From: Amanda Scholes on behalf of Planning.Responses
Sent: 20 January 2021 10:27
To: Planning Scanning
Subject: FW: CM/48/201/DOC - Bairds Farm Shop, Field Rear of Crookthorn Lane, Climping, BN17 5SN

SCALE @ A1 As Noted	ENGINEER MBD
PROJECT NUMBER 2868	DRAFT NJ
STATUS S2	APPROVED TST
DATE April 18	
PROJECT ORIGIN BCH ICS	DWG NO / REVISION 003 P07
PHASE 01	
LEVEL XX	
TYPE DR	
ROLE C

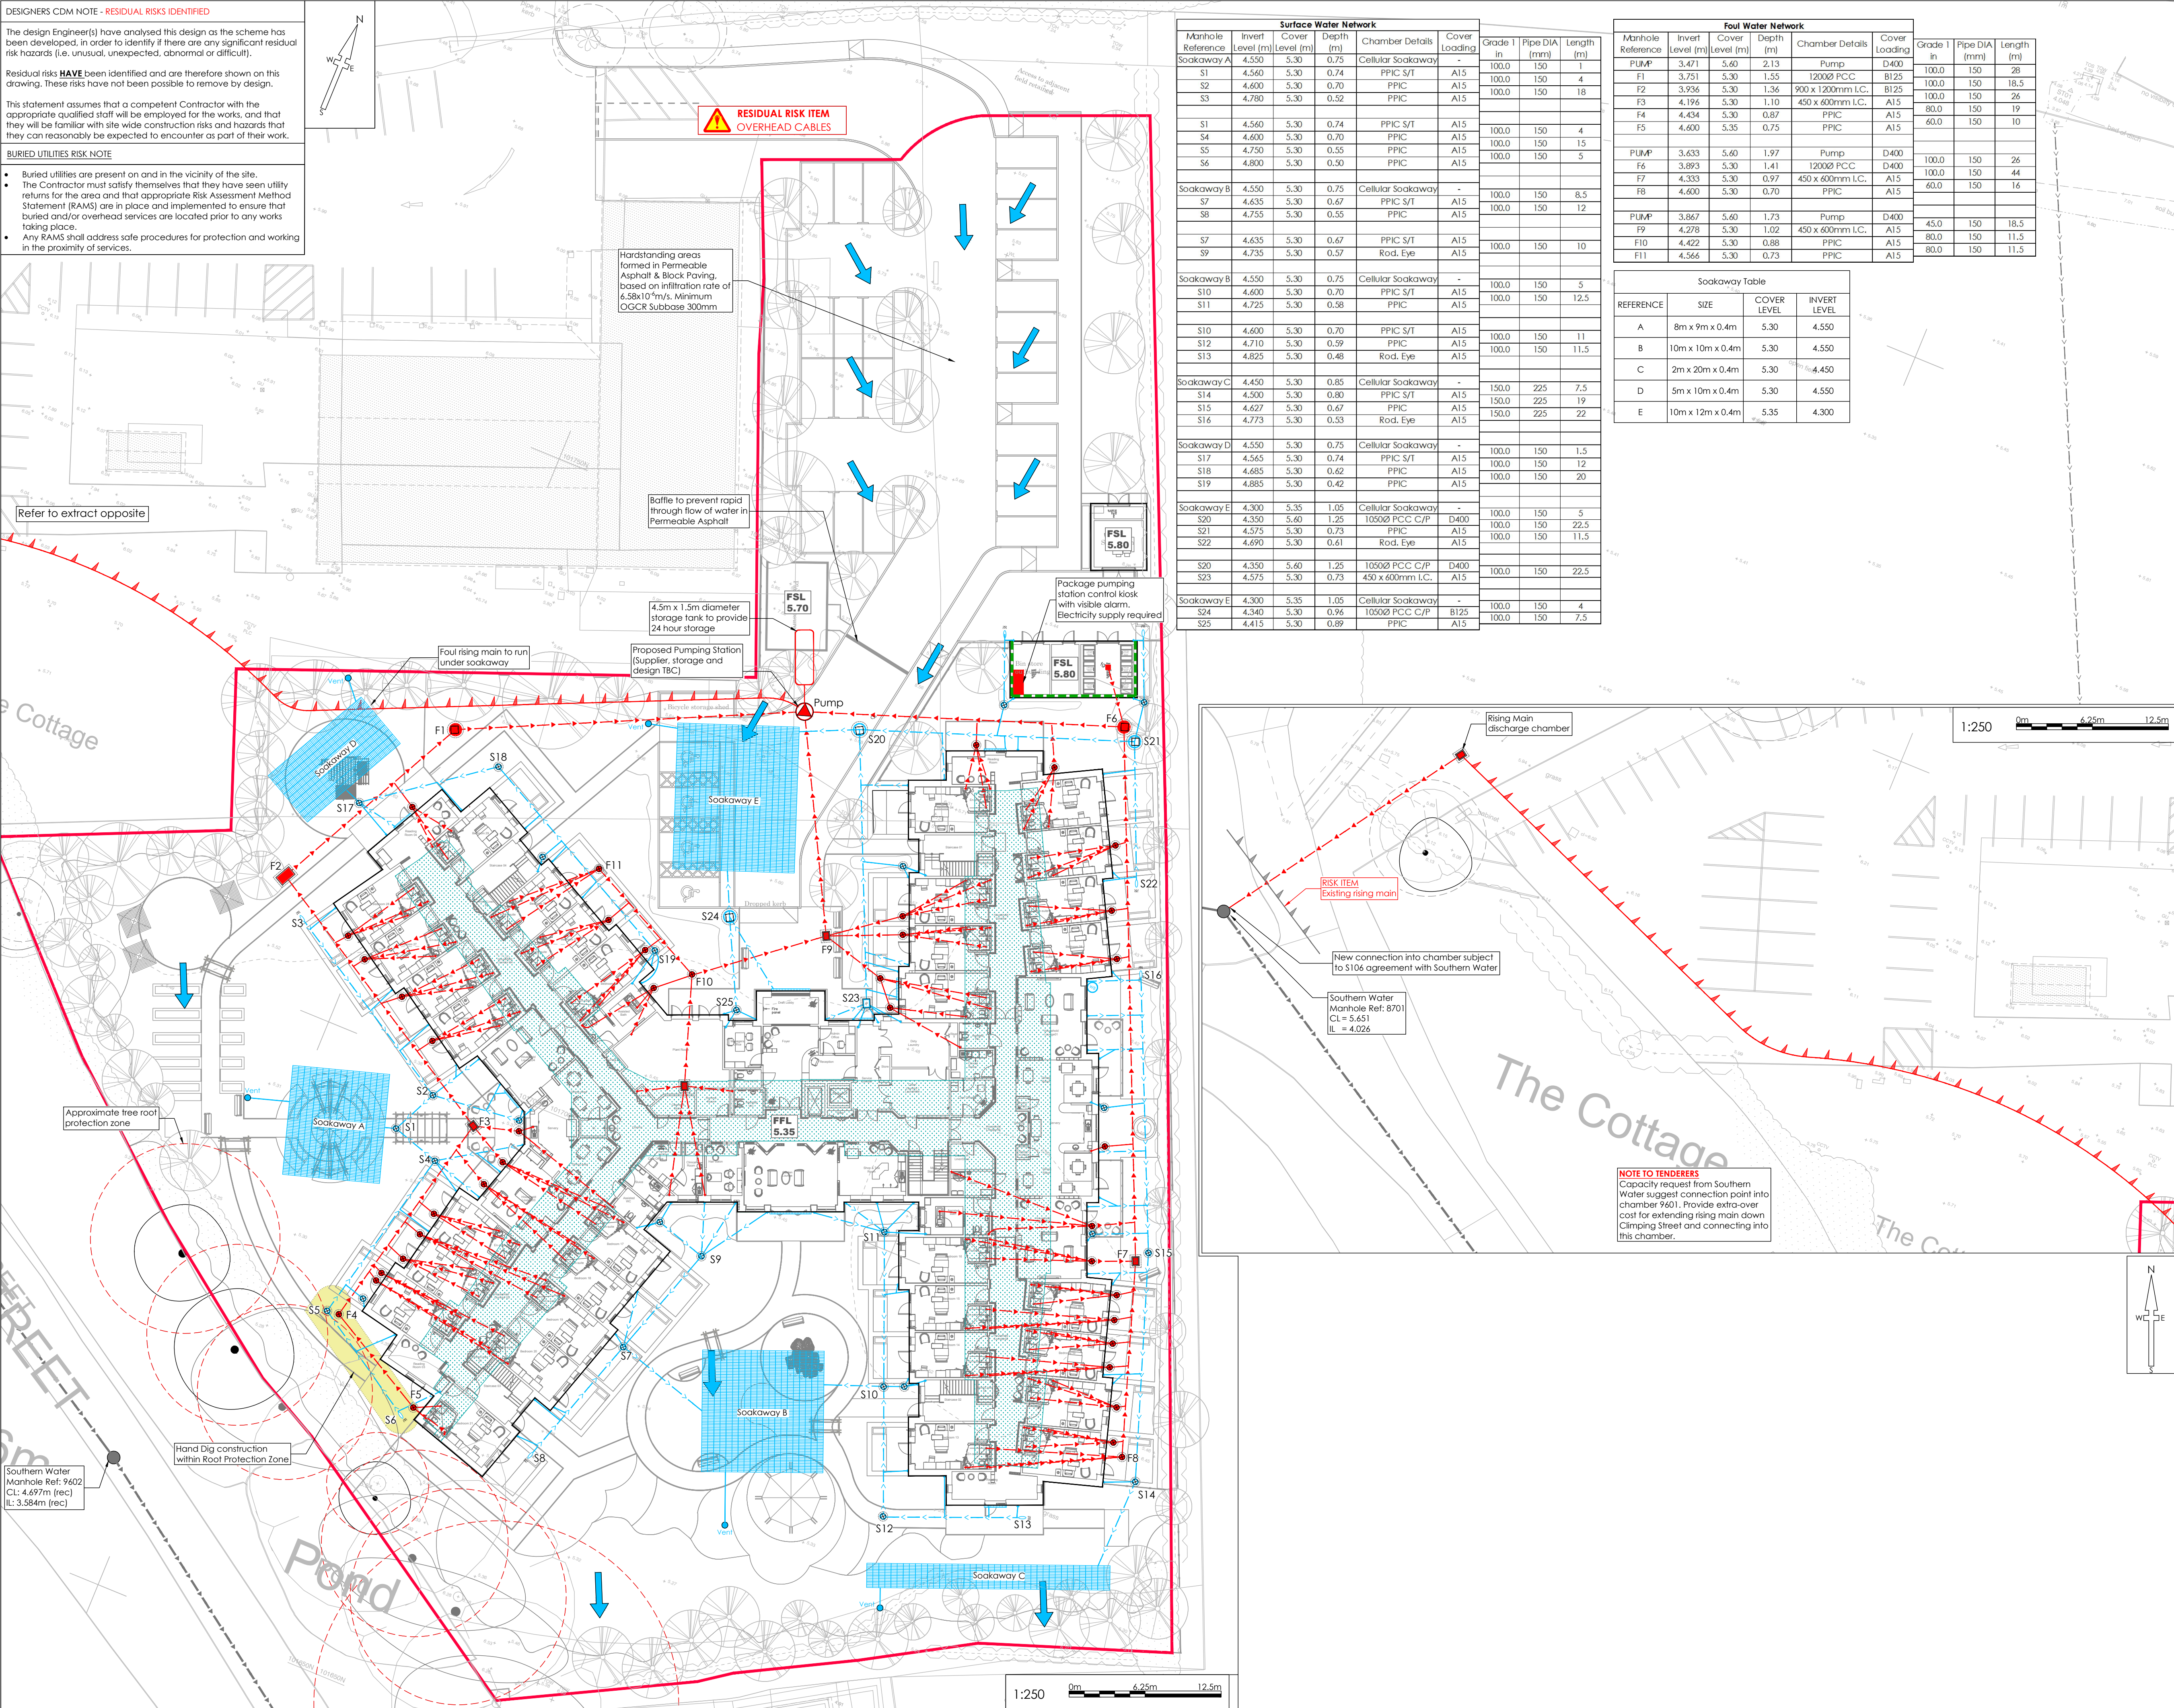
1. Please supply a figure showing the groundwater monitoring locations.
2. I note that Soakaway E has an invert at over 1m depth, based on the groundwater monitoring results near this location the design may need to be revised. (potentially link provided between permeable paving and this soakaway to ensure you have the required volume above peak groundwater level?)
3. Please supply a catchment plan- i.e. a layout which clearly shows the areas (and the size of these areas) that are draining to each soakaway.
4. Please label all pipes with diameters and falls.
5. We will require updated construction detail drawings and maintenance manual. Please include on the construction detail drawings the required crate type- or criteria they have to fulfil in terms of minimum acceptable cover depth.
